From: Simon Davis
Sent: 21 May 2019 16:07
To: 'Lauren Wiltshire' [REDACTED]
Cc: Laura Gibbons <Laura.Gibbons@arun.gov.uk>
Subject: RE: Planning Consultation on FP/42/19/DOC

Engineers Comments Regarding Condition 7

Site Address: Land off Stanhorn Grove Stanhorn Grove PO22 8FS

Description of Works: Approval of details reserved by condition imposed under ref
FP/171/18/PL relating to Condition Nos
5,6,7,8,9,10,11,12,13,14 & 24.

PRIVATE DRIVE - BITUMINOUS CONSTRUCTION WITH PERMEABLE SUB-BASE Scale 1:20

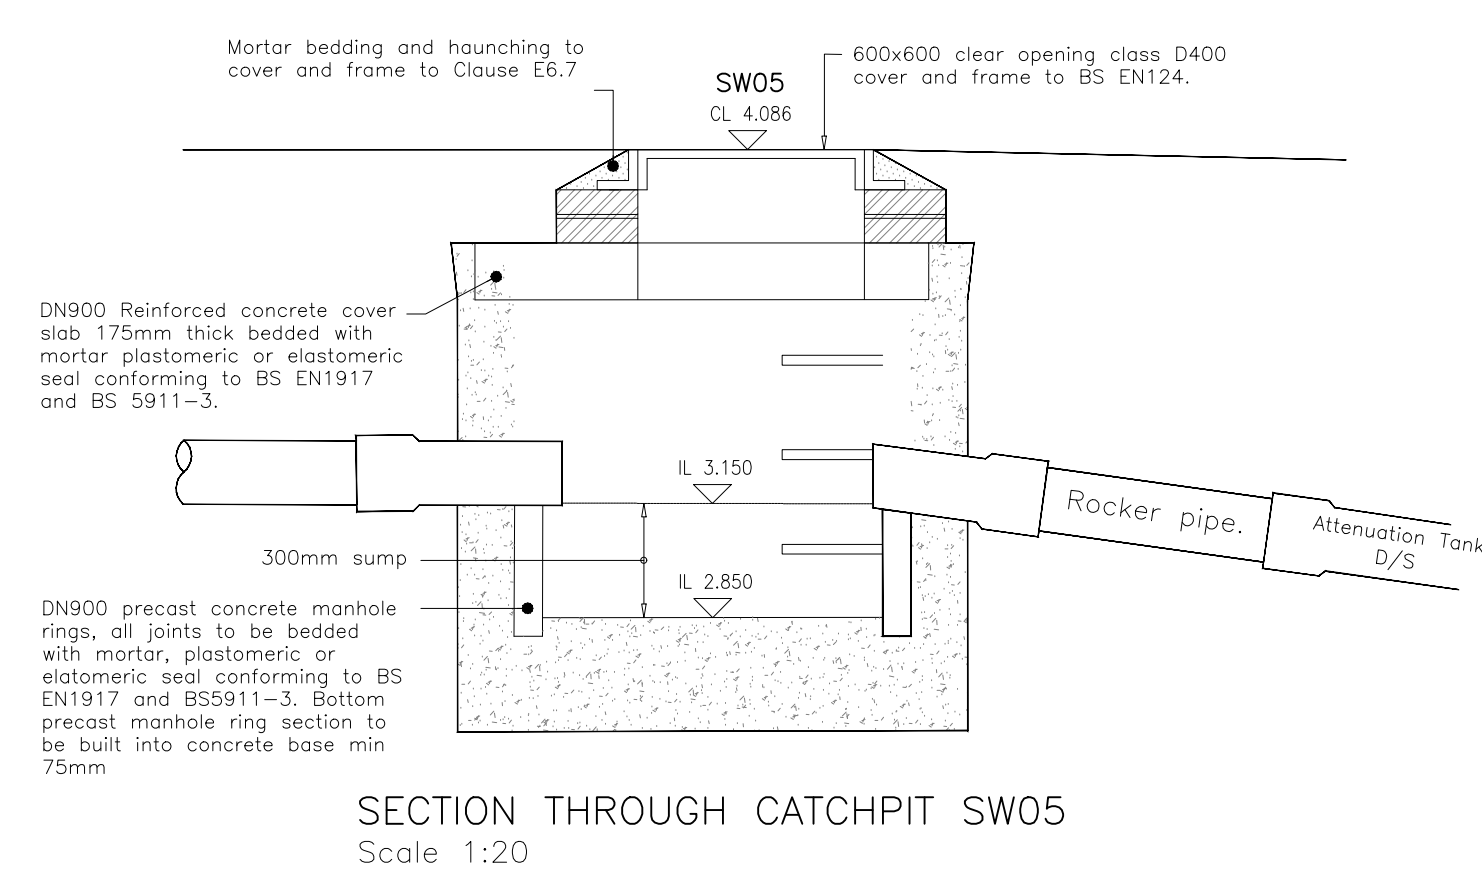
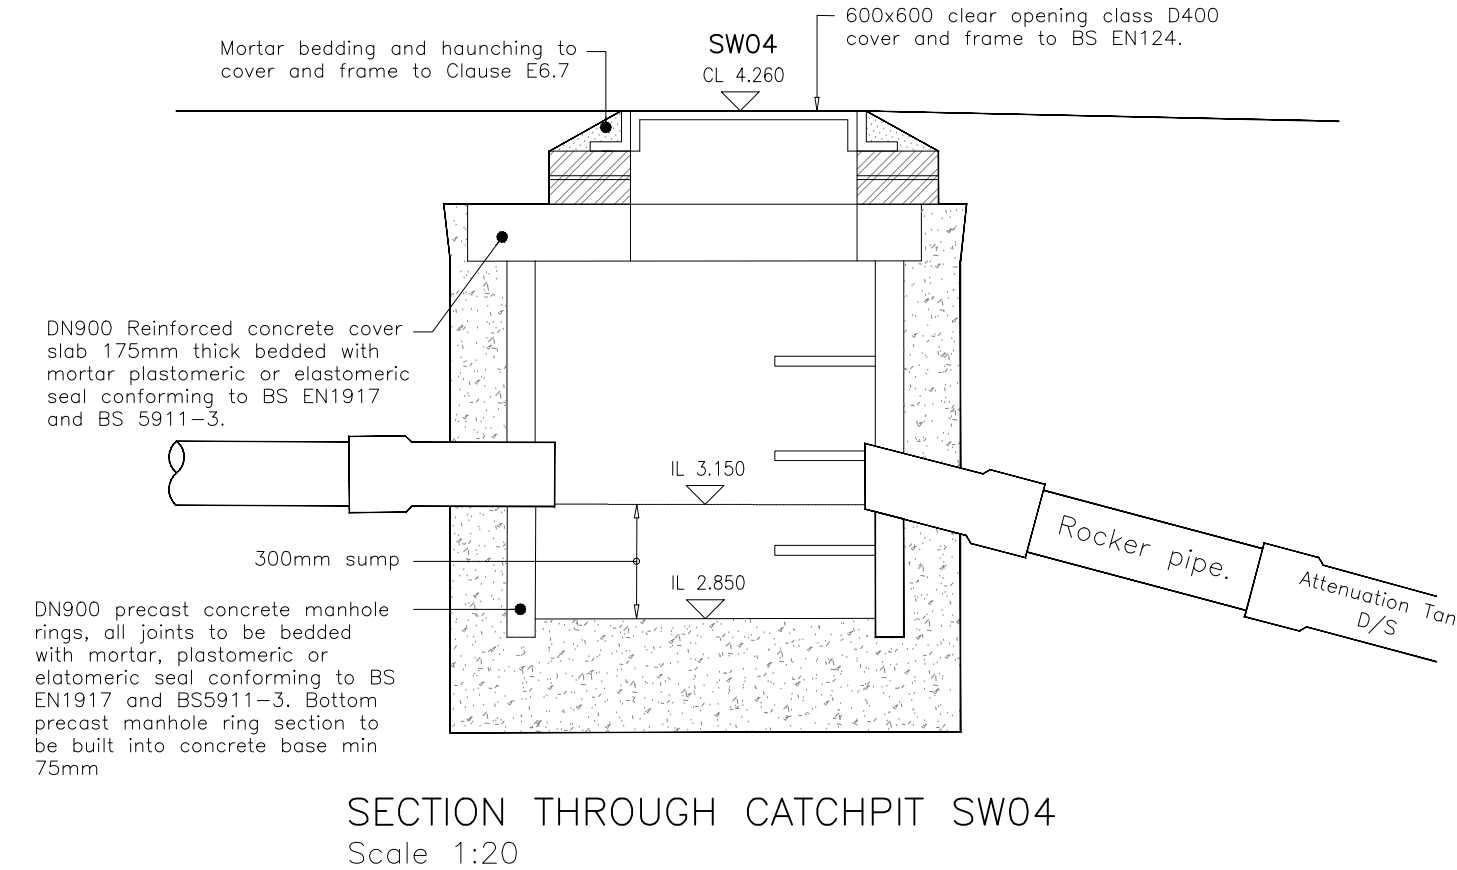
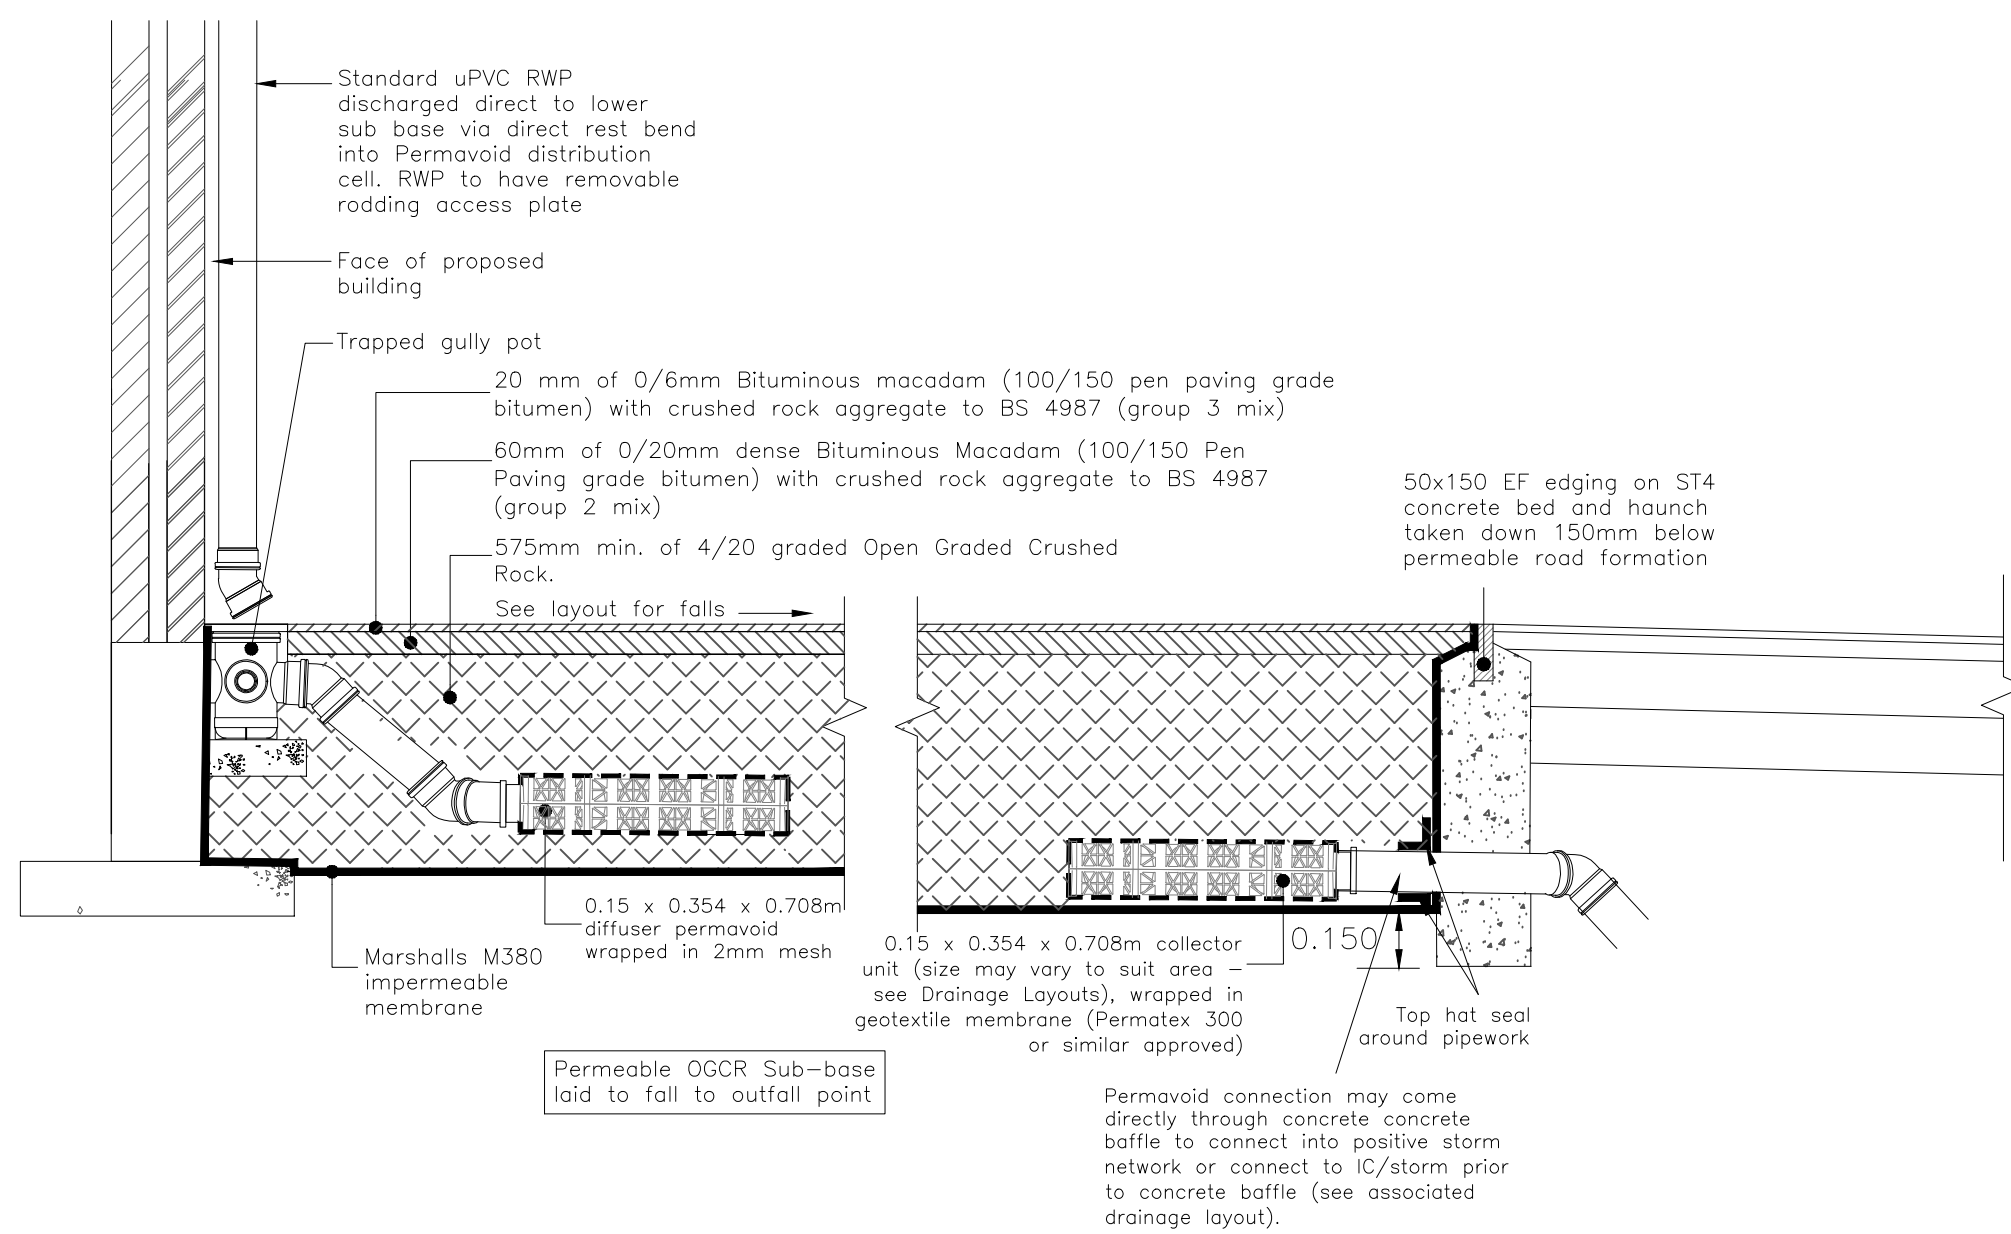
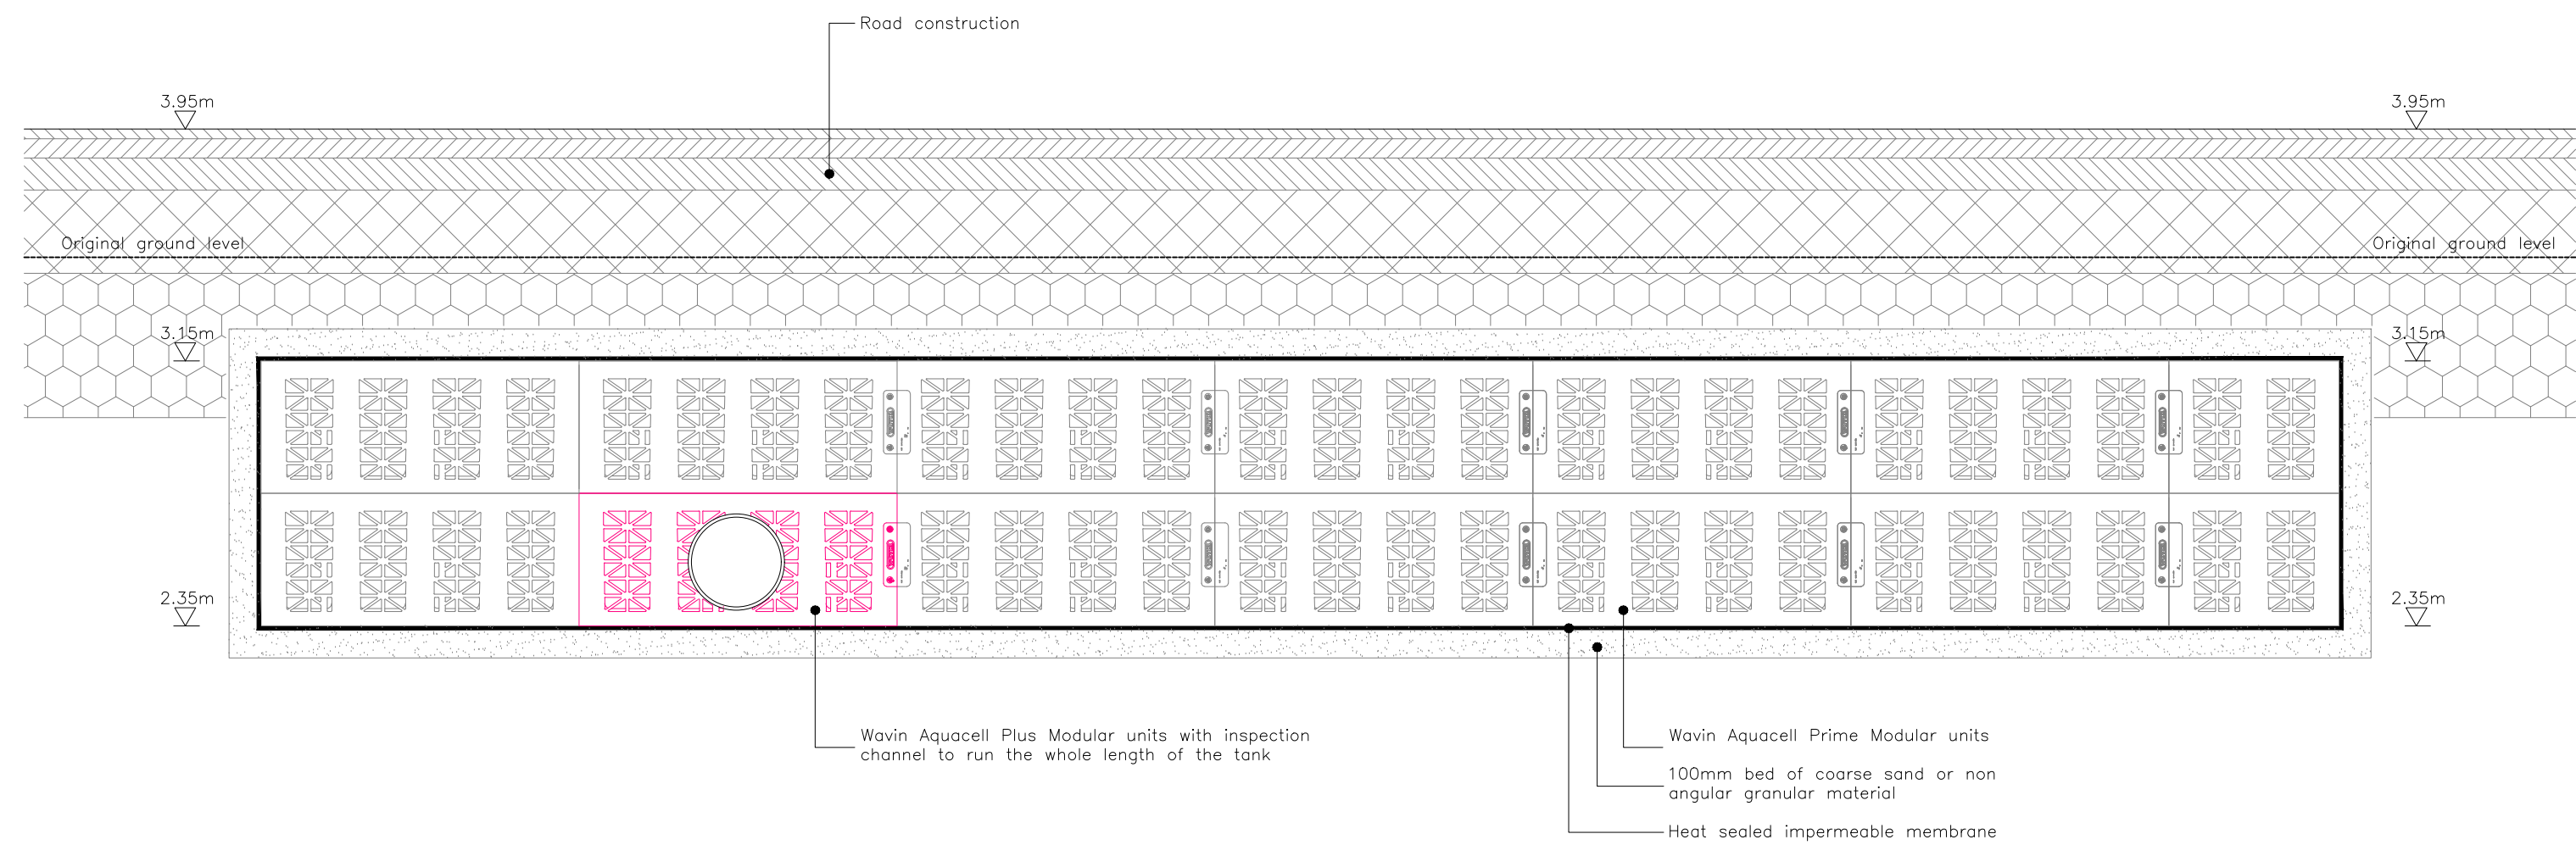
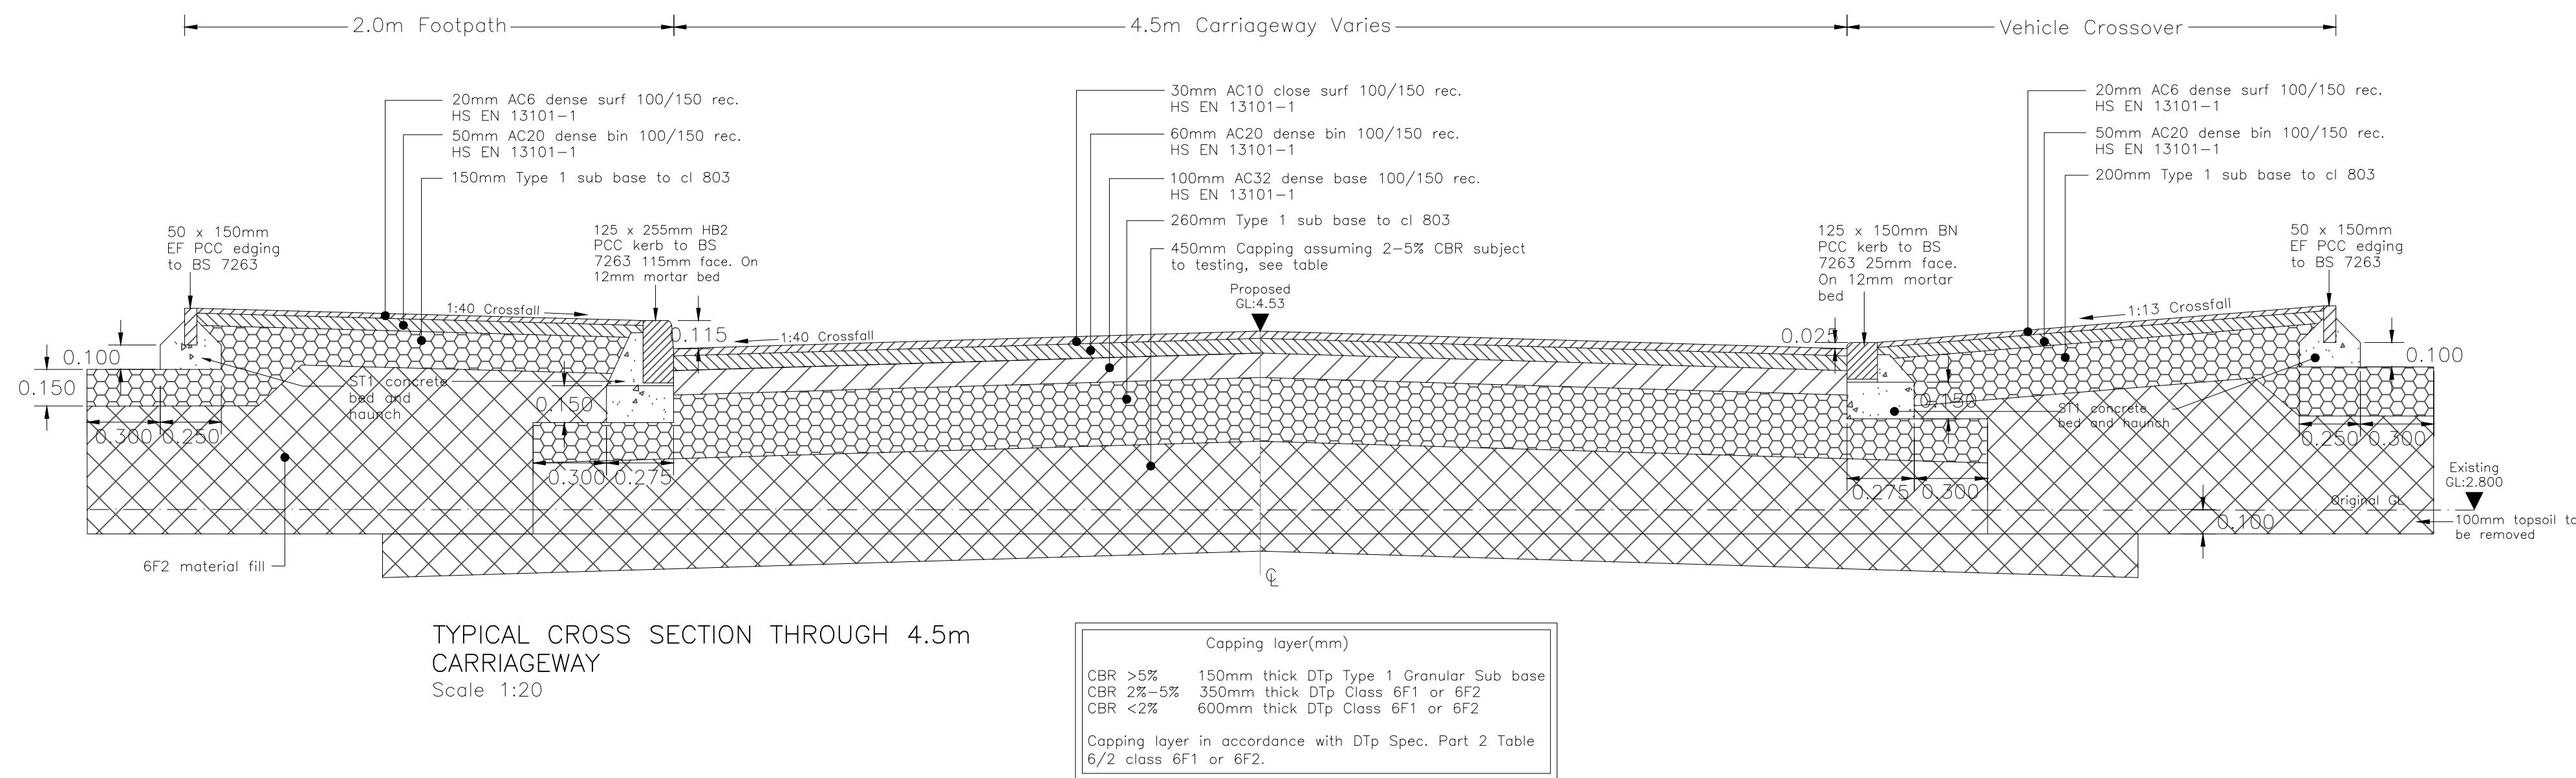
1. Catchpits must be provided upstream of all connections into the attenuation tank.
2. No construction detail drawings have been provided. Please provide construction detail drawings of manholes, catchpits, permeable paving, attenuation tank and hydrobrake.
3. There is conflict between the landscaping proposals and the drainage proposals. Trees must not be located on or near attenuation tanks. Please revise the landscaping proposals.
